CITY OF ALBUQUERQUE

October 29, 2012

**Re: San Clemente Apartments, Lots 7 & 8, Gibson Tract "A",
Portion of Tract 25-A, Grading and Drainage Plan
Engineer's Stamp date 10-26-2012 (G-14/D006B)**

A PROPOSED
GRADING AND DRAINAGE PLAN
FOR
SAN CLEMENTE APARTMENTS
BUILDINGS "E" & "F"
SAN CLEMENTE AVENUE N.W.
ALBUQUERQUE, NEW MEXICO

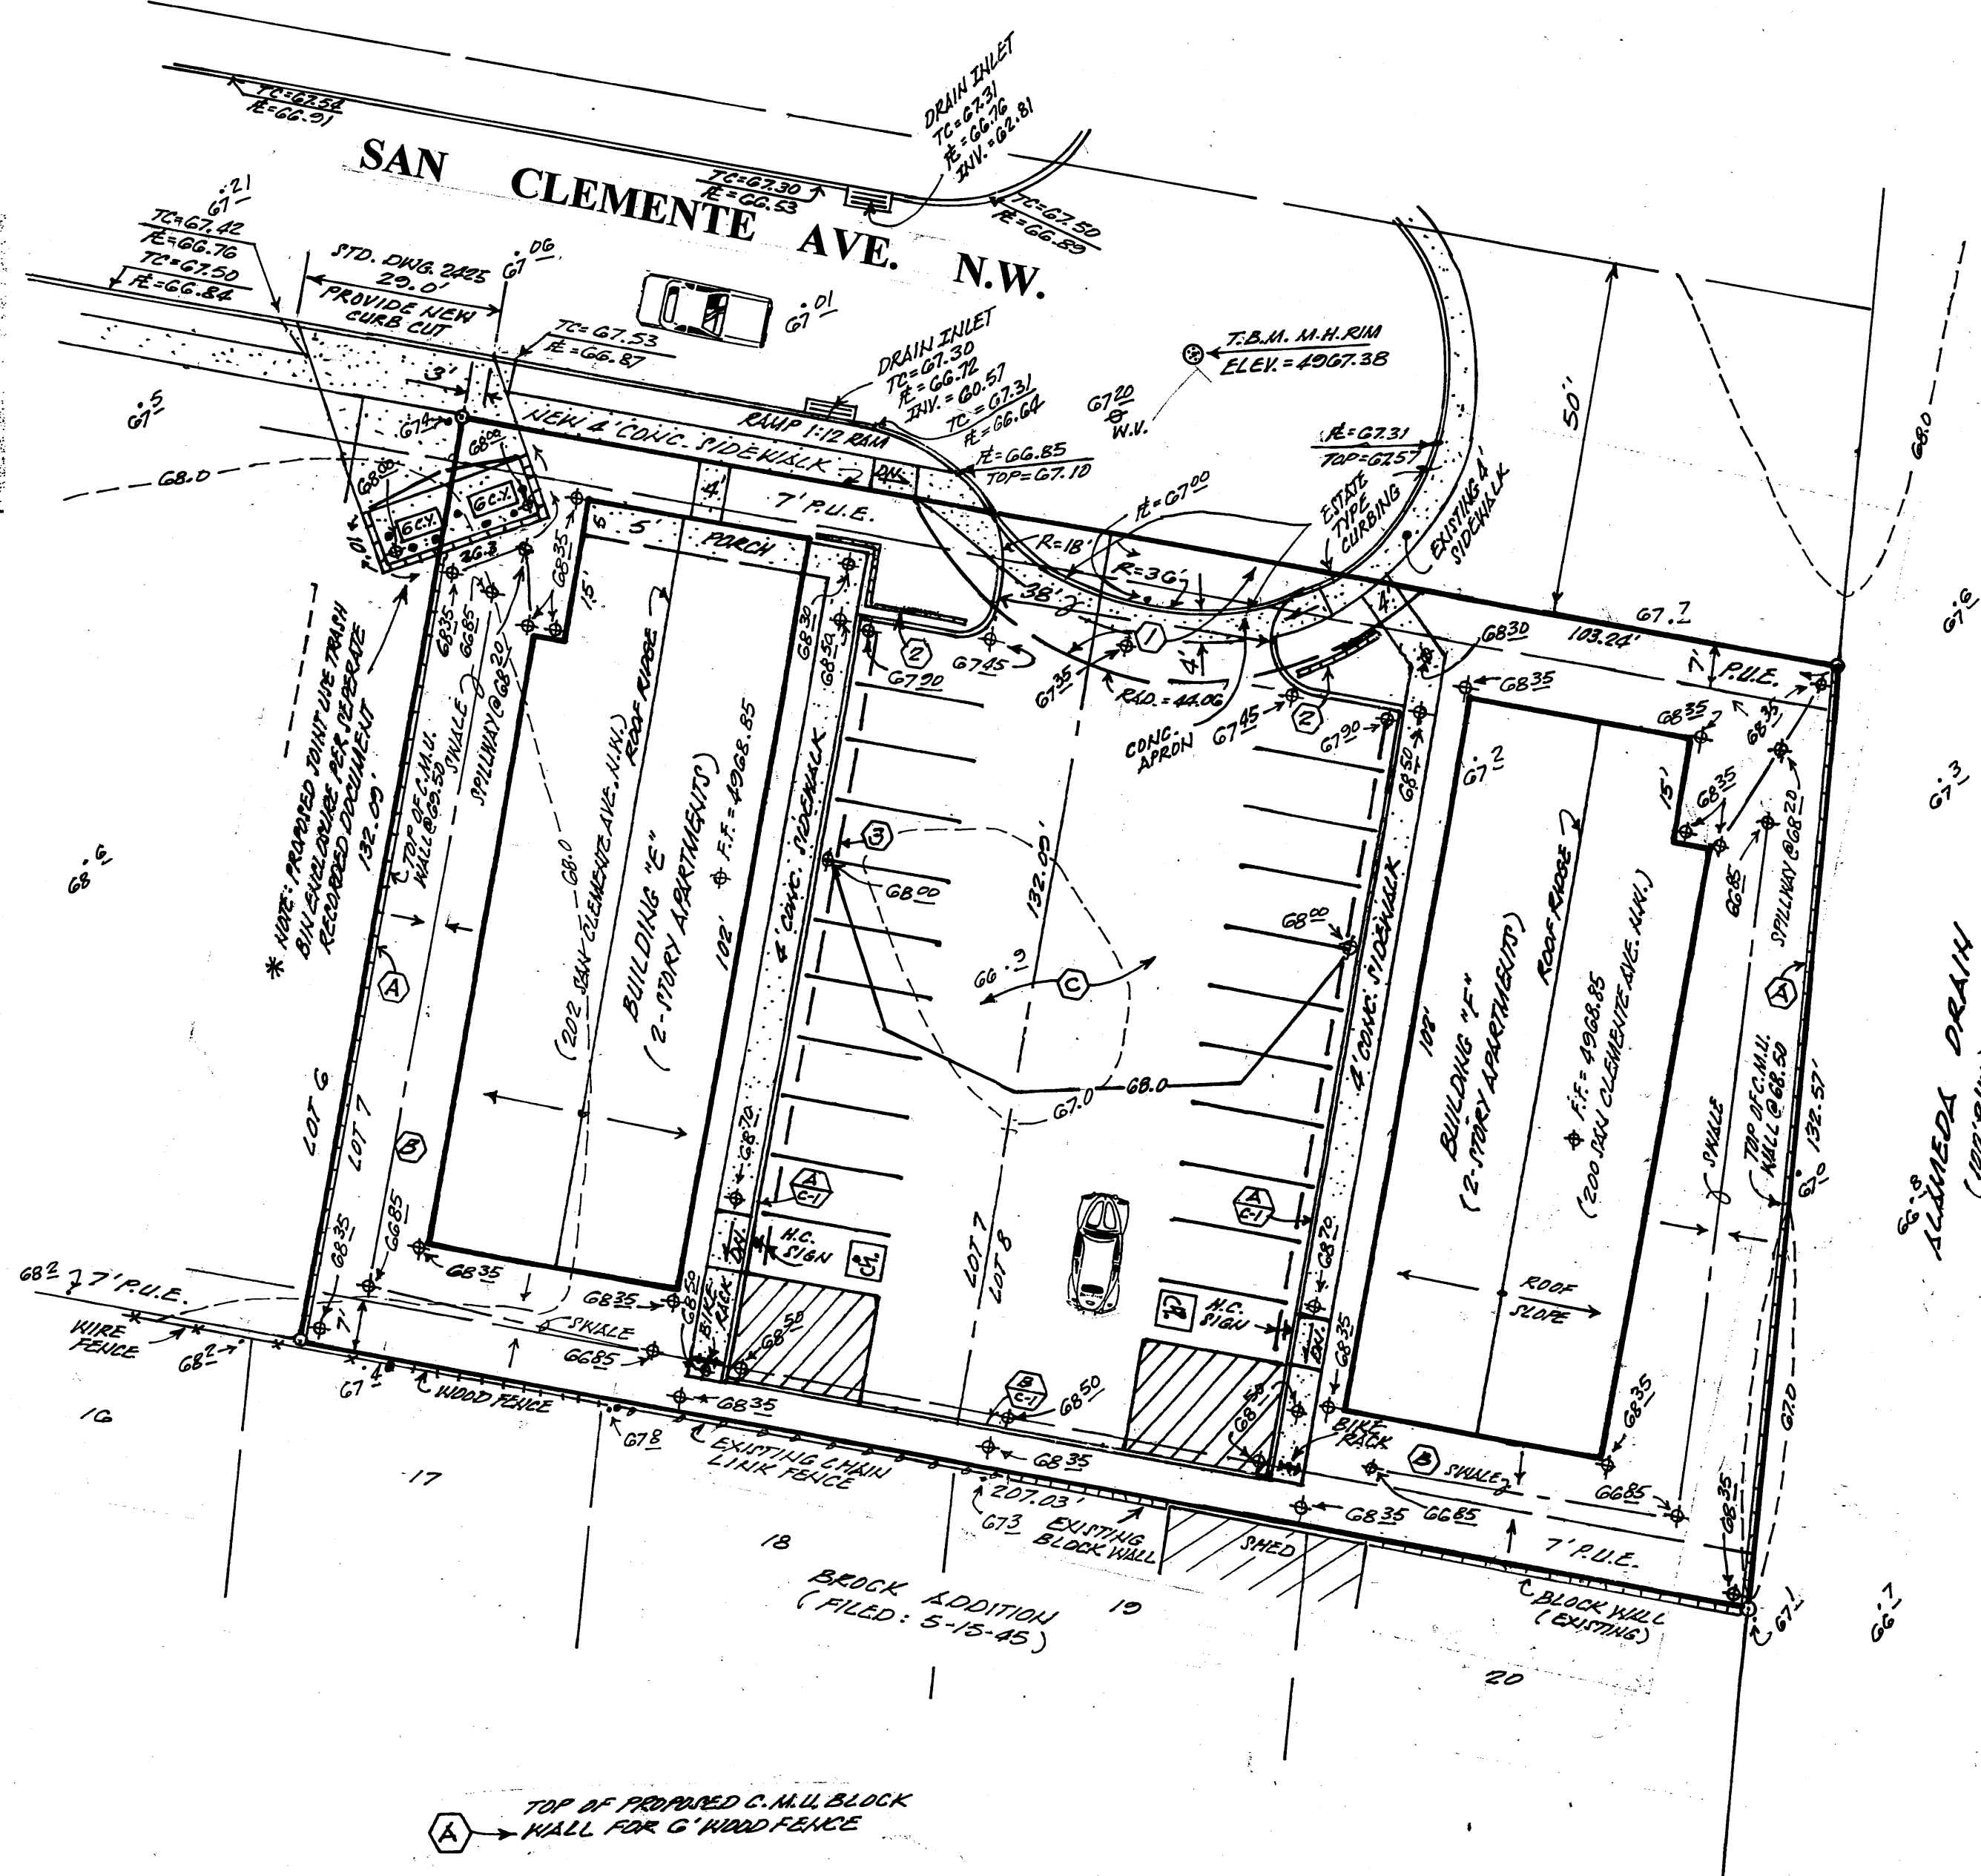
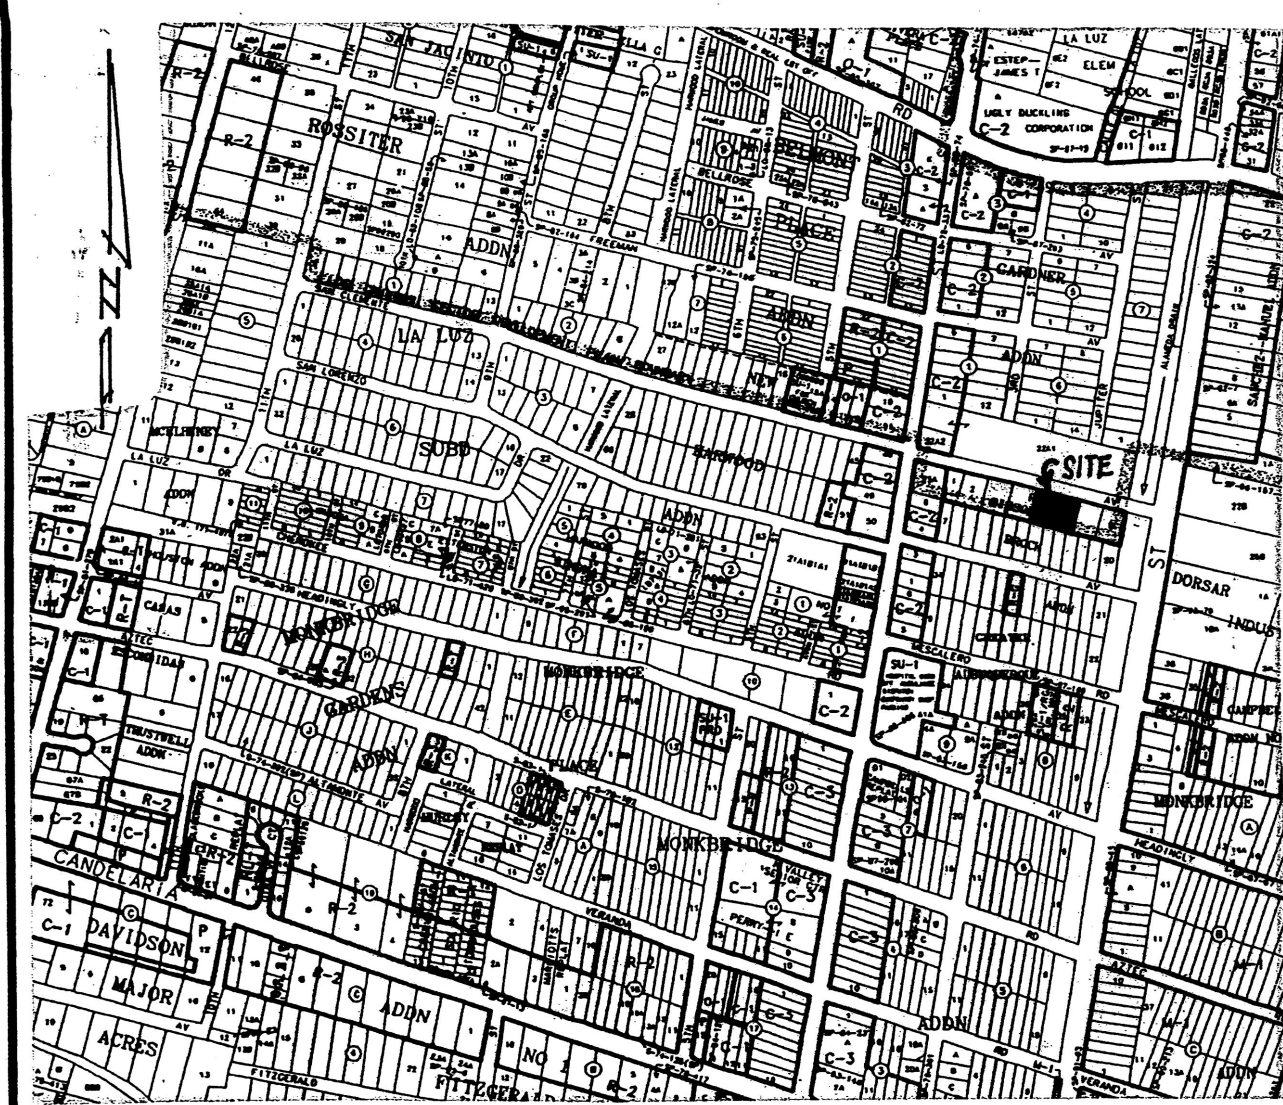
Based upon the information provided in your submittal received 10-29-2012, the above referenced plan is approved for Building Permit. We are recommending that the 2" pipe under the sidewalk to be changed to 4" pipe.
